Recommendation Report for Planning Permission for Works or Extension to a Dwelling

REF NO: BR/117/22/HH

LOCATION: 82 Victoria Drive
Bognor Regis
PO21 2TA

PROPOSAL: Erection of part first floor extension over existing ground floor including part two storey element to rear with Juliette balcony to front elevation, widening of drop kerb and replacement boundary wall.

Drawing:
Proposed Floor plans

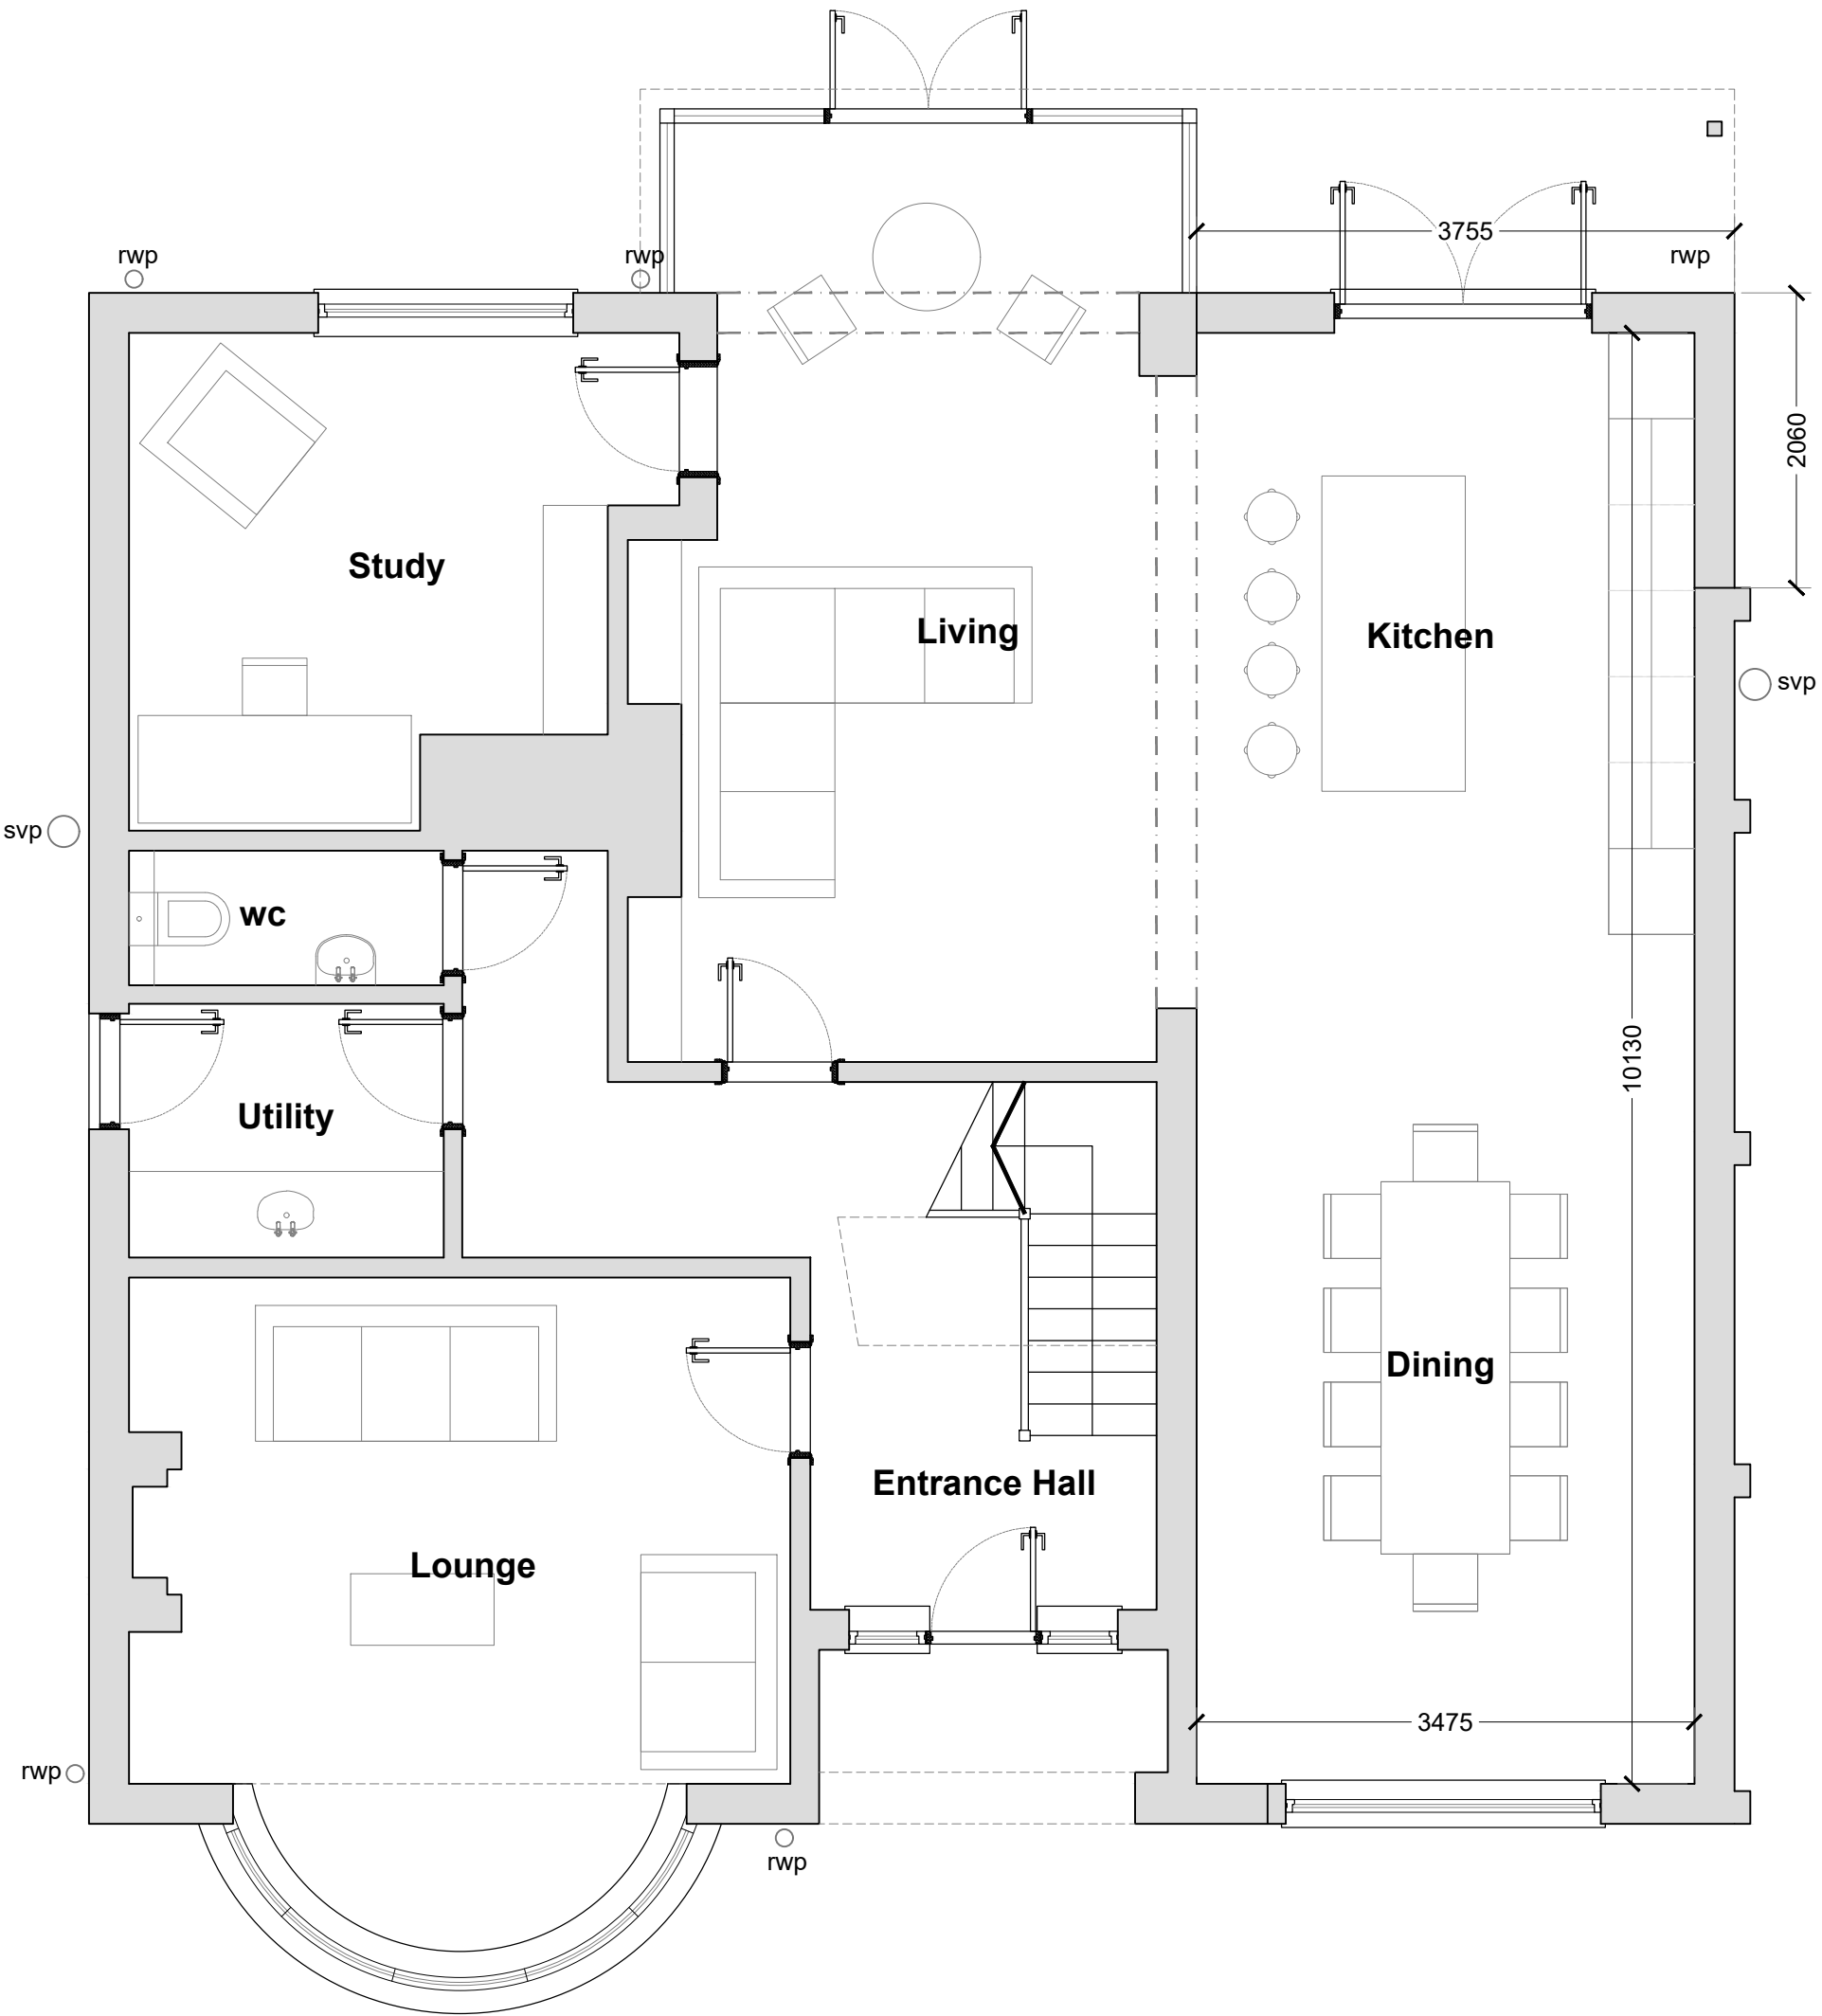
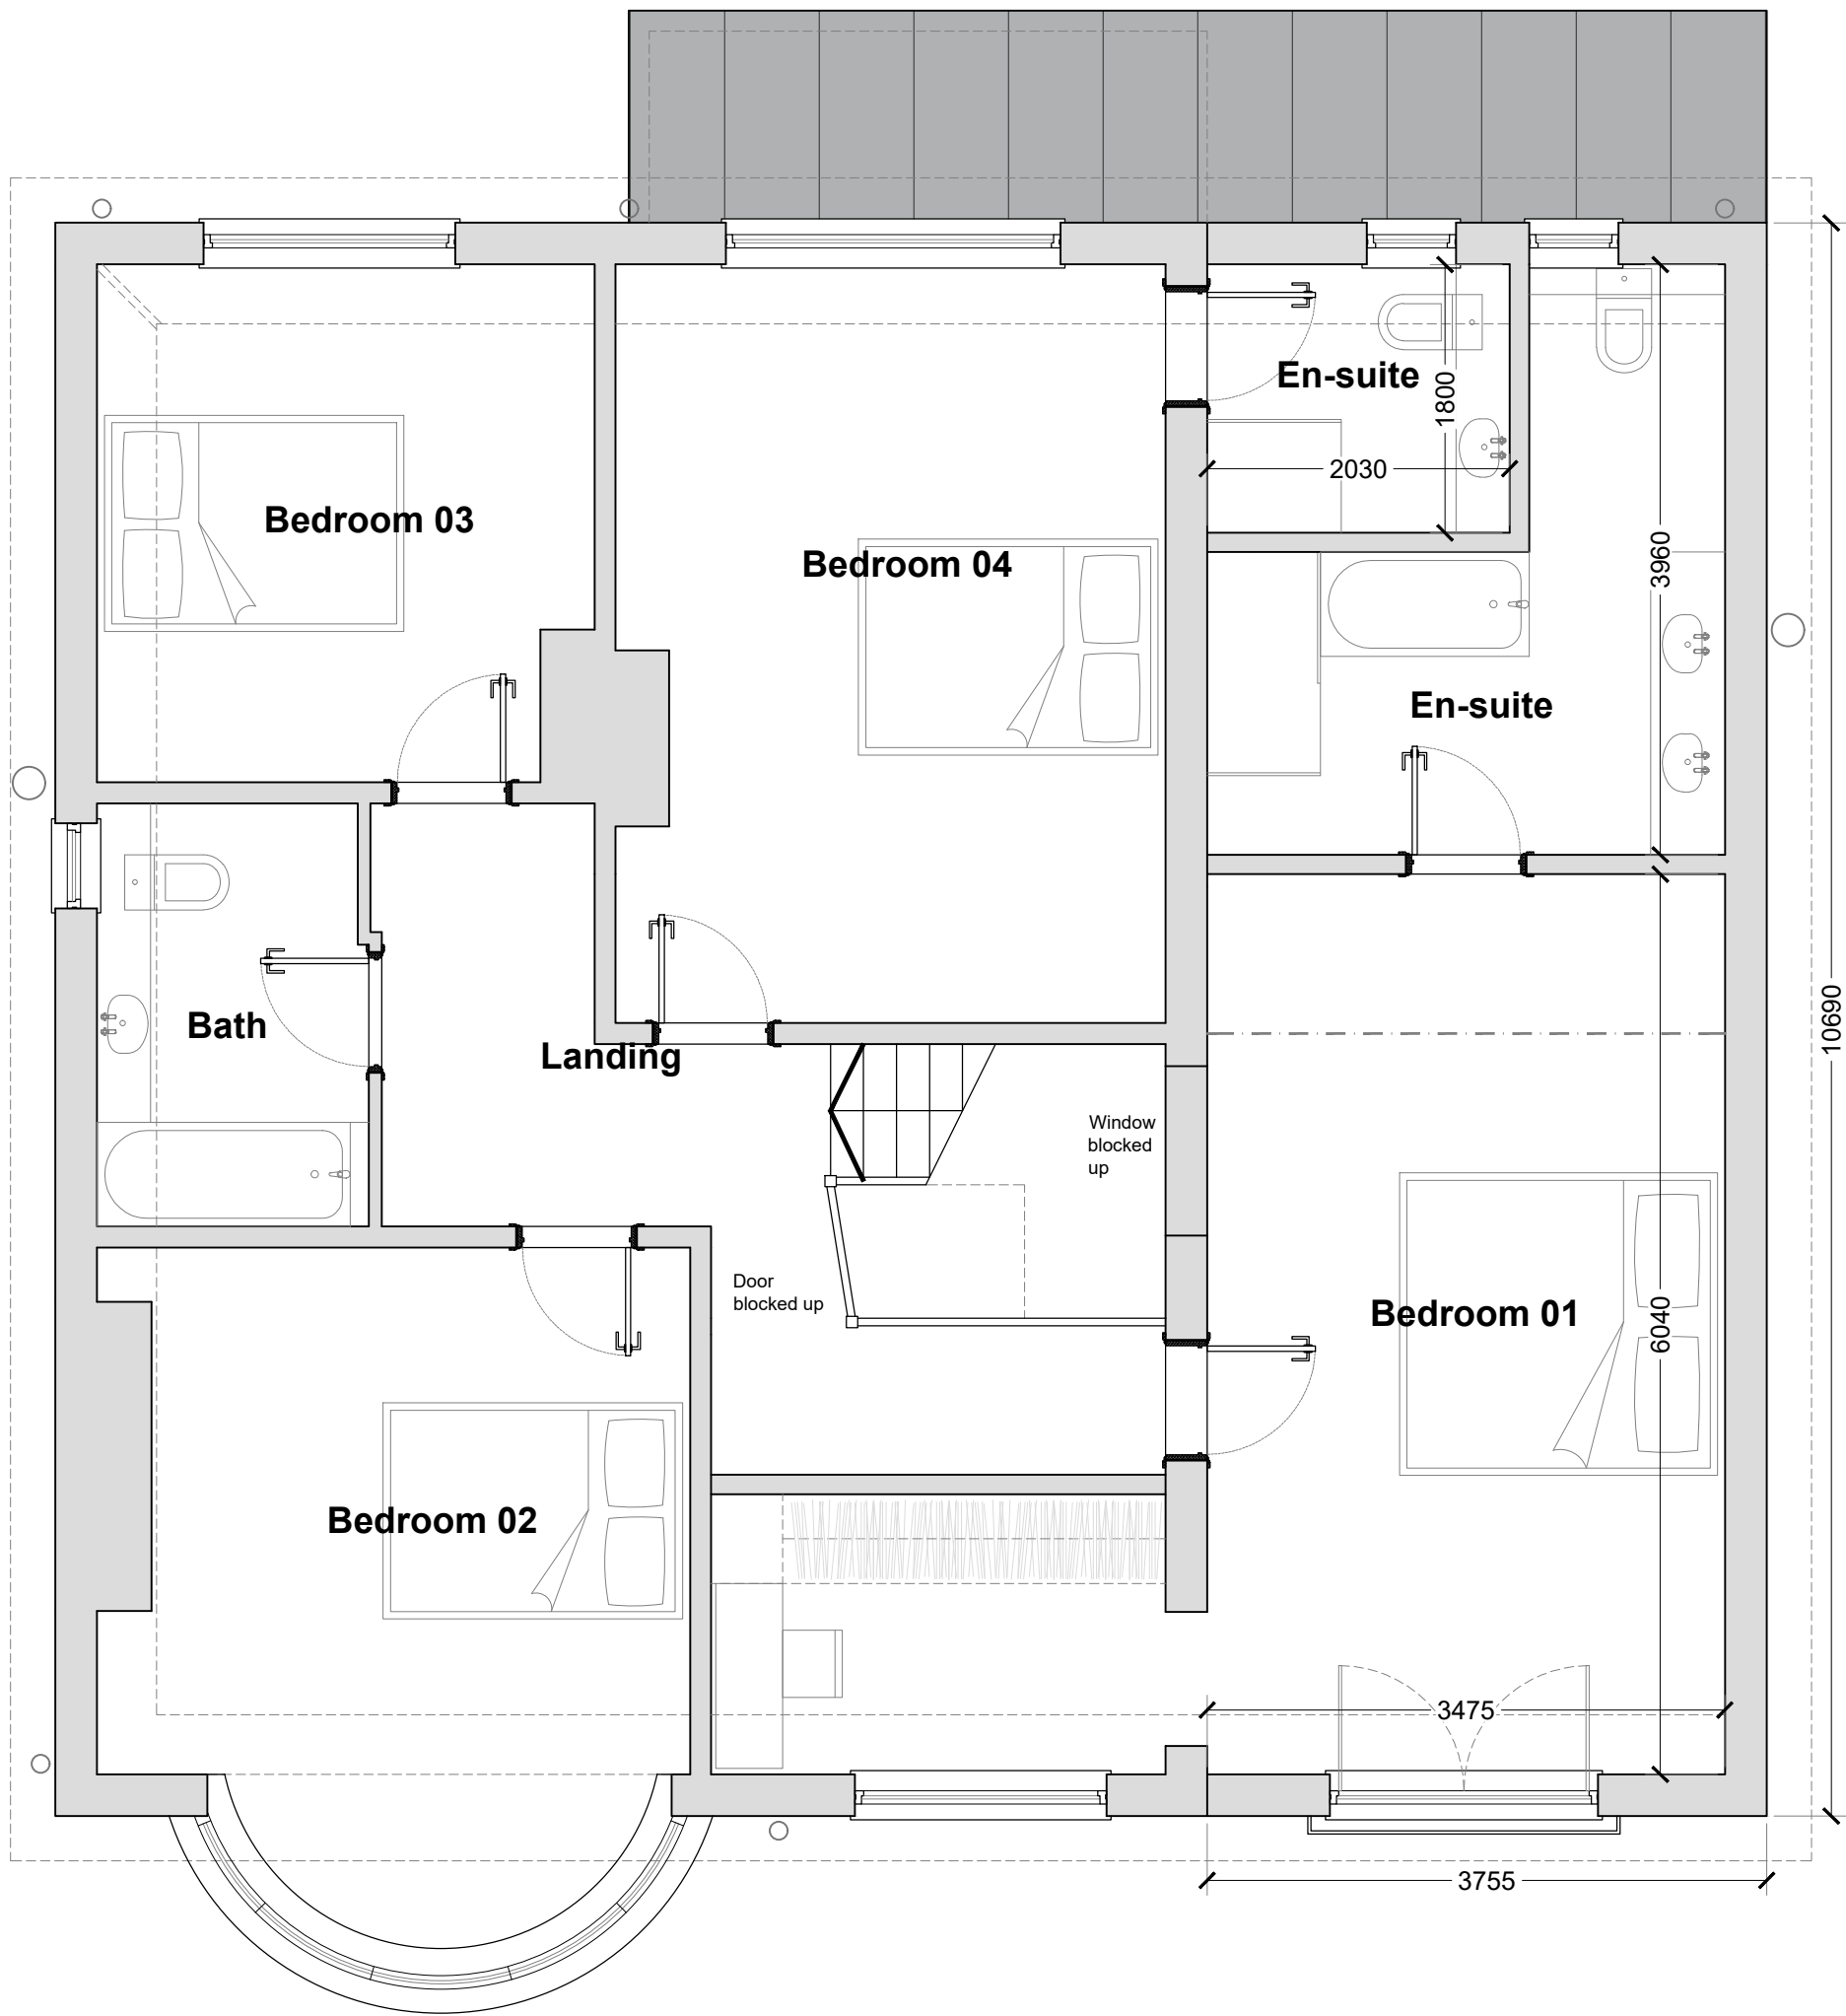
The dwelling is a detached two storey property with a single storey side addition. The proposal will construct a first floor above the side extension. The side extension does not extend the full side elevation, retaining 2m to the rear. As such a two-storey extension will be constructed to the rear of these so it meets with the rear two storey building line.

The proposed first floor extension will not result in significant overbearing or overshadowing upon No.80 with the development running along its side elevation. There will also be a modest two storey addition to the rear of the side extension. This has a depth of 2m and meets in line with the rear two storey building line of the host dwelling. The extensions will not result in adverse harm upon amenity as it does not extend beyond the neighbouring building line and does not intersect a 45-degree angle when draw from

the rear facing windows. There is one first floor side facing window to No.80 which will be subject to some overbearing as a result of the first floor extending across it, however this will not be significant in which a refusal is justified.
